Application by Tillbridge Solar Limited for Tillbridge Solar Project
The Examining Authority's first written questions and requests for information (ExQ1)
Issued on 19 November 2024

Responses are due by Deadline 3: Tuesday 10 December 2024

PROJECT NUMBER

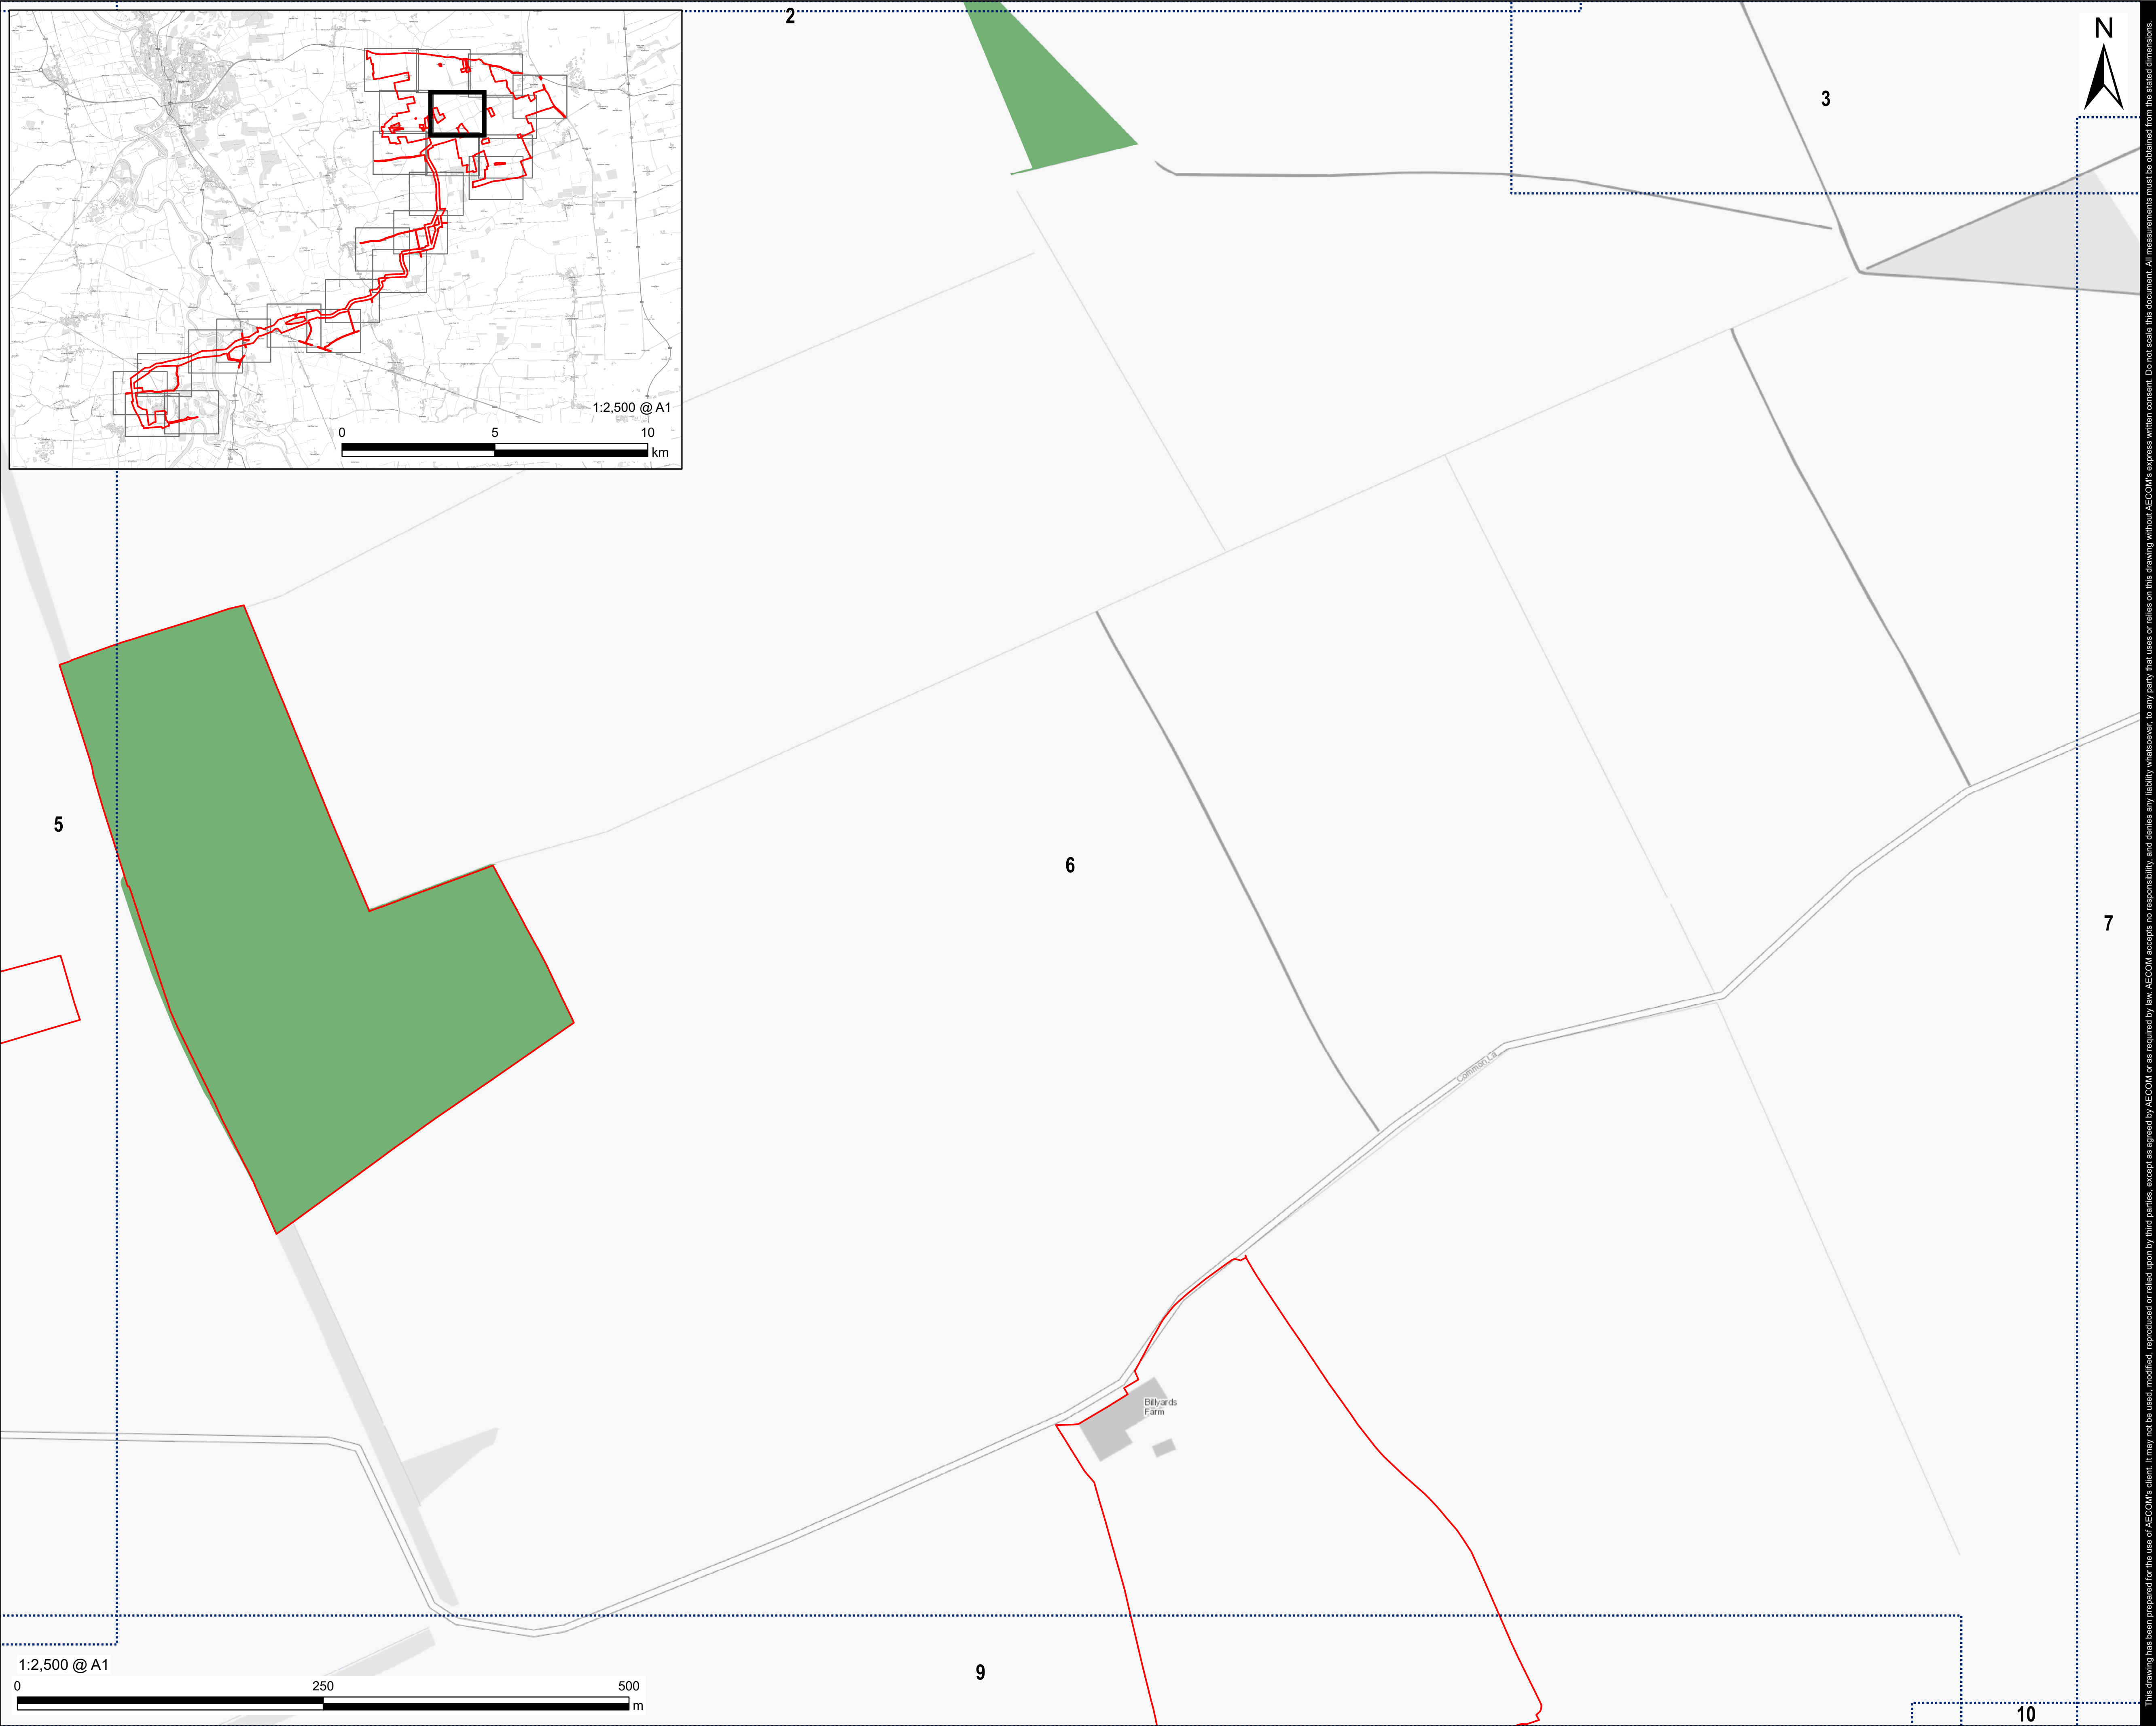
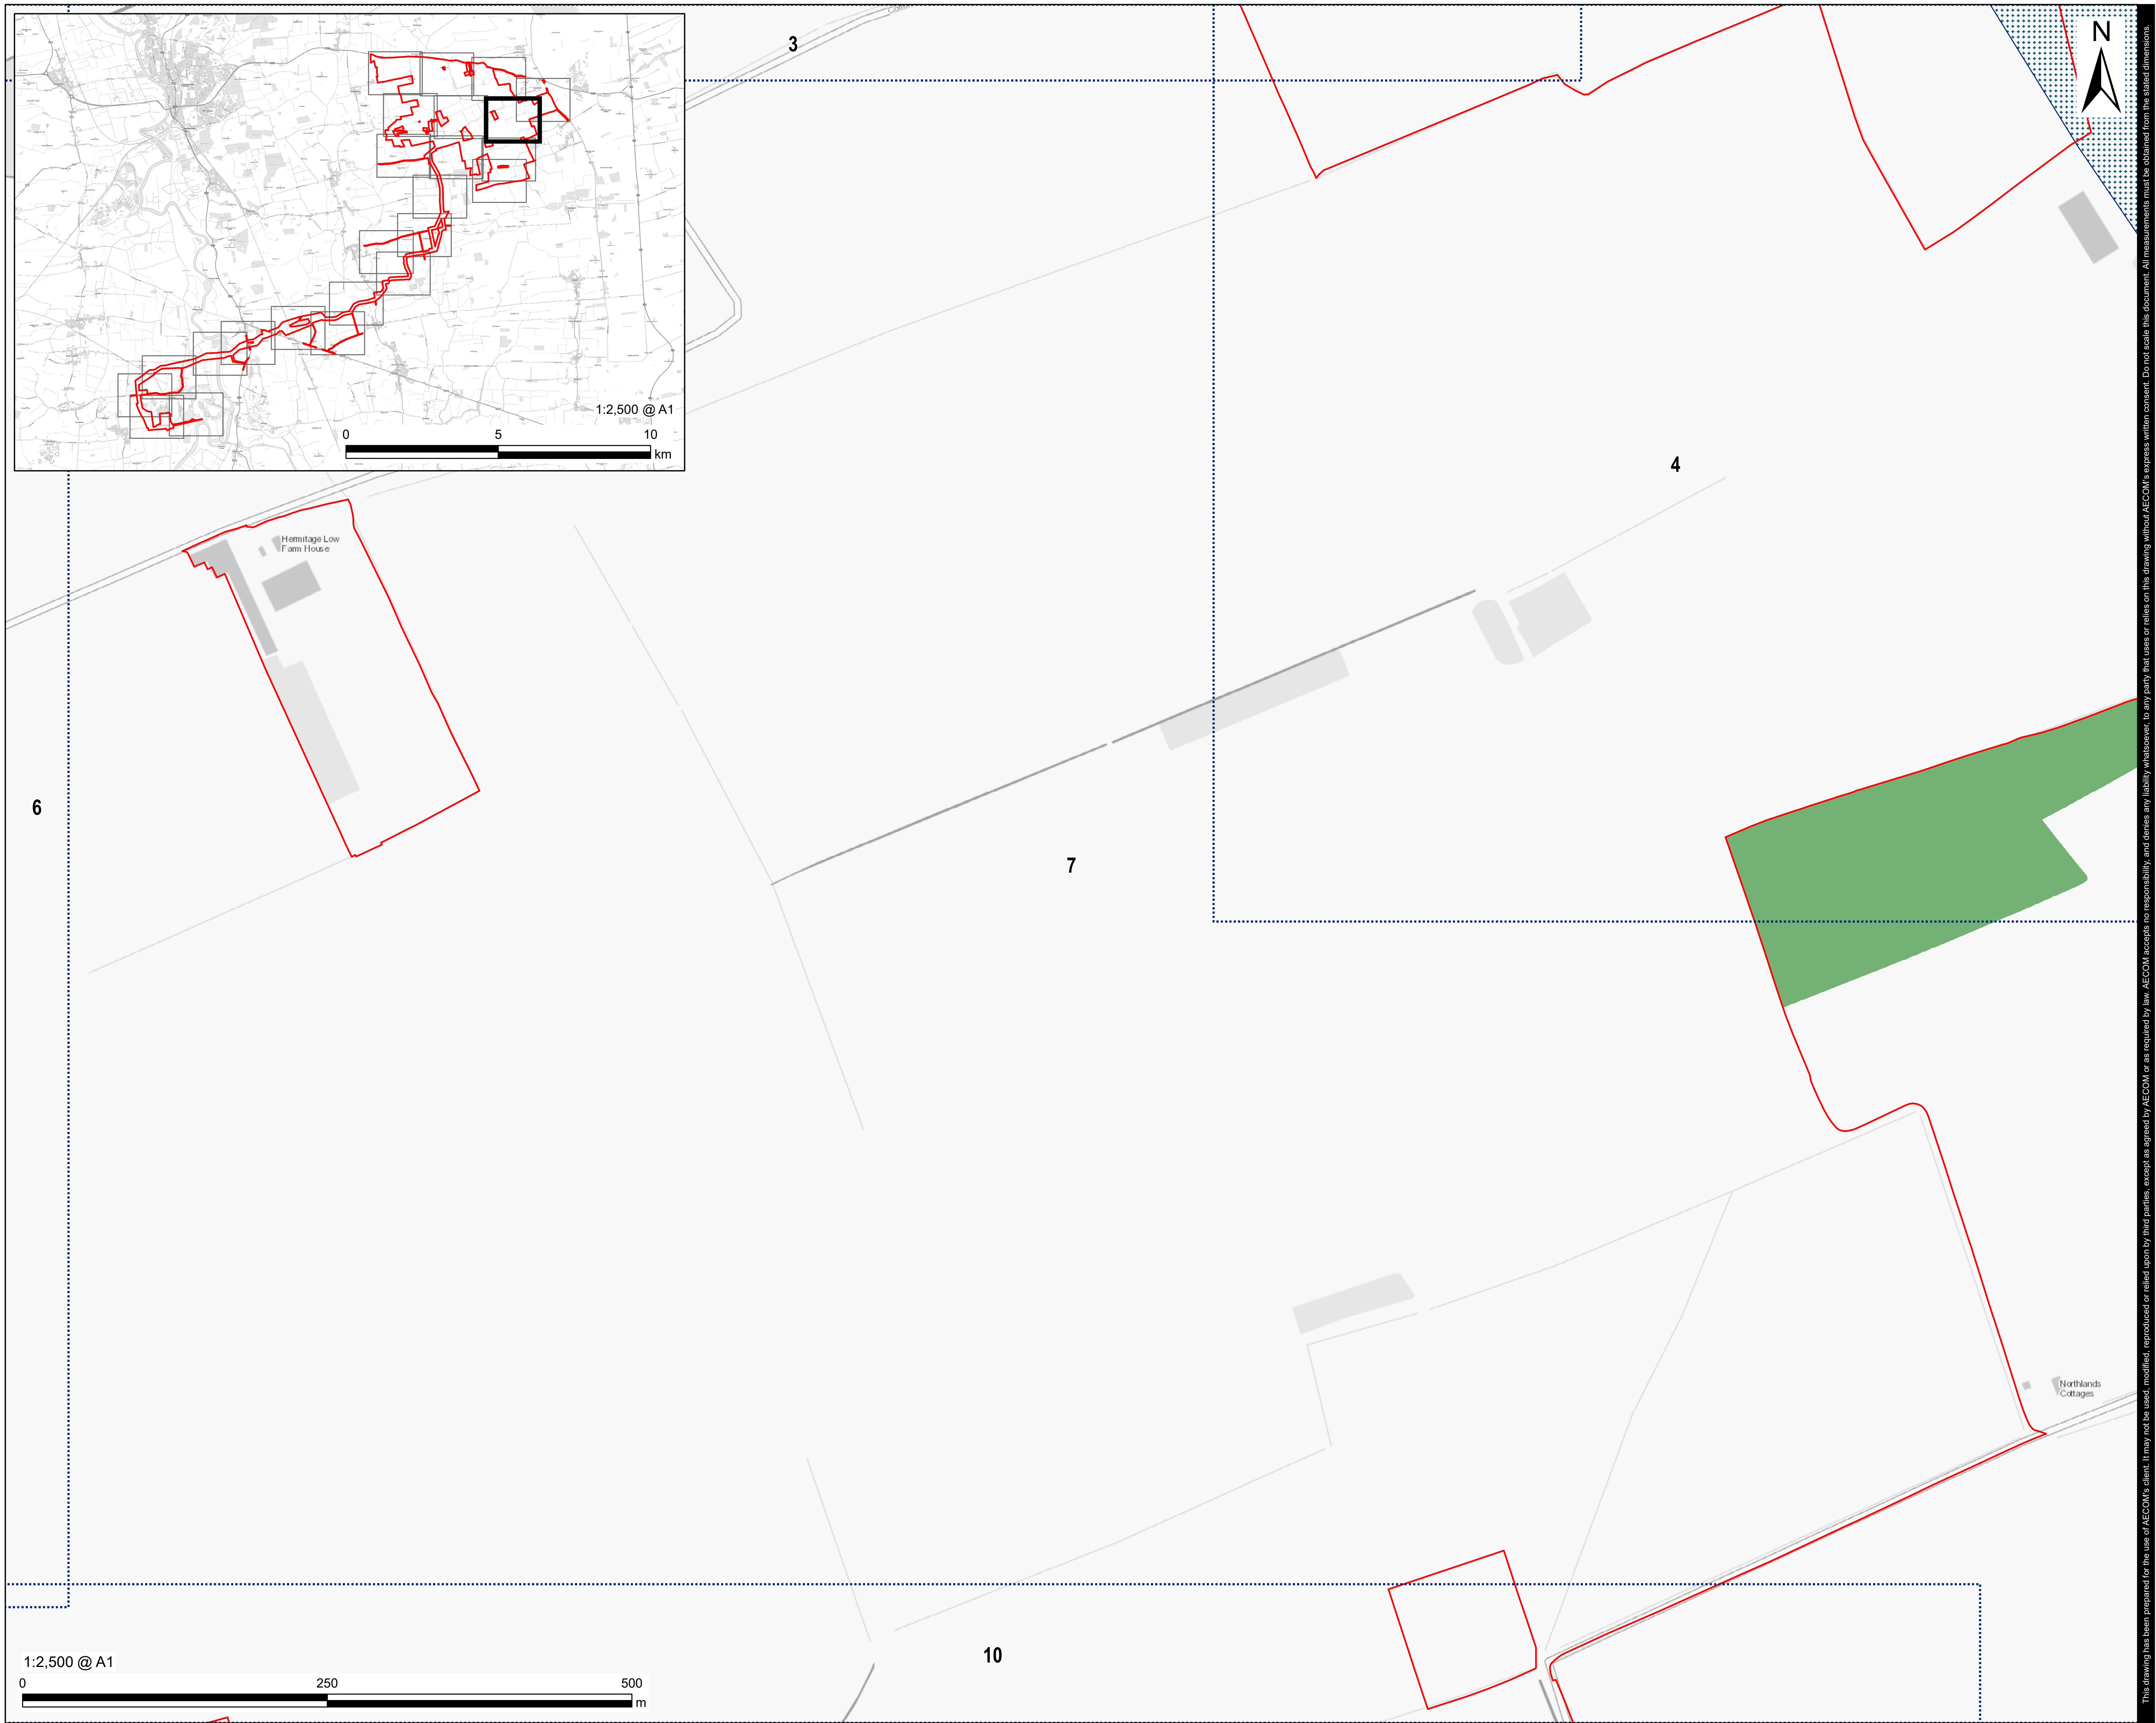
ExQ1	Question to:	Question:
		<p>please provide an updated copy of the phase 1 habitat maps depicted in ES Figure 9-3 [APP-166] which do not identify any target notes.</p> <p>Also please provide a plan demonstrating how the risks of a bentonite breakout during directional drilling would be managed and controlled.</p>
Habitats Regulations Assessment (HRA)		
Q1.2.14	Natural England	<p>HRA</p> <p>Does Natural England (NE) have any representations in relation to the Applicant’s responses to Natural England’s Relevant Representation [RR-208] provided in the document titled ‘Applicant’s Responses to Relevant Representations’ (PDF pages 10-28) [REP1-028]? Could NE also please provide a response on updated ES Appendix 9-12: Habitats Regulations Assessment Report [REP1-058] and in particular the conclusions in relation to:</p> <ul style="list-style-type: none"> a) the distances used to screen in European sites to the assessment; b) the rationale for screening out the Golden Plover qualifying feature of the Humber Estuary Ramsar site; c) conclusions in relation to no Likely Significant Effects (LSE) from water quality to the Humber Estuary Ramsar site and Humber Estuary Special Area of Conservation (SAC); and d) the conclusions in respect of in-combination effects with the One Earth Solar and Great North Road solar projects.
